Longfield Solar Farm

Statement of Common Ground – Environment Agency

| Document Reference: EN010118/EX/8.4(~~B~~)A

Figure 3 : SFRA Fluvial Flood Zone Mapping 65% Climate Change - Fluvial Modelling Report

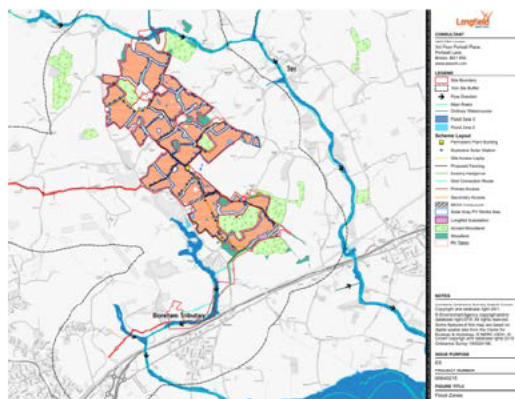
Ref	Sub-topic	Stakeholder Comment	Applicant's Response	Status
		<p>However, in light of the requirements in paragraph 4.8.8 of EN-1, it cannot be ascertained accurately from the information provided whether there is any risk to critical parts of the infrastructure without knowing what levels these are set at and what the flood level would be for the 0.1% AEP plus the maximum credible climate change uplift values to peak river flows.</p> <p>The FRA should assess if further modelling is required to establish flood levels noting the requirements of the NPS EN-1 4.8.8 and the requirement to establish the 0.1% AEP plus the maximum credible climate change uplift values to peak river flows.</p> <p>Whilst this may seem negligible, it is currently unknown what flood level this represents and how infrastructure could be affected. Infrastructure should be 'designed and constructed to remain operational and safe in times of flood' as required by the 'Flood and Coastal Change' guidance document.</p> <p>It needs to be clear from the applicant's documentation and risk assessments as to whether there are any features of the infrastructure that are critical to its operations close to the boundaries of the flood zones. If there are critical elements of the infrastructure close to the boundaries of FZs 2 and 3 then the 37% peak river flow uplift should be applied.</p> <p>This should be through hydraulic modelling of the River Ter and Boreham Brook (tributary). [Statutory consultation and Relevant Representation]</p>	<p>The level of 48m AOD is not reached on the right bank of the water course for approximately 1km. With a smaller river catchment than the River Ter (614ha, 87% smaller) in this location, it is considered flood levels will not have capacity to reach 48m AOD across such a width.</p> <p>Appendix 9A Flood Risk Assessment [EN010118/APP/6.2] discusses this in more detail.</p> <p>Given all PV panel installations and other above ground structures, buildings or equipment are in Flood Zone 1 no further modelling has been undertaken. Justification and plans to support the approach have been provided in Appendix 9A Flood Risk Assessment [EN010118/APP/6.2], including a plan showing the Scheme and Flood Zones (Figure 3).</p>

12	Development areas and Flood Zones	Appendix A of the FRA shows the layout of the development. It should also have a map showing built development in relation to the flood zones (including climate change, for the lifetime of development and beyond, as a sensitivity test). [Statutory consultation]	The updated FRA is available in Appendix 9A Flood Risk Assessment [EN010118/APP/6.2] . Figure 3 shows areas where above ground development may be located in relation to Flood Zones.	Agreed
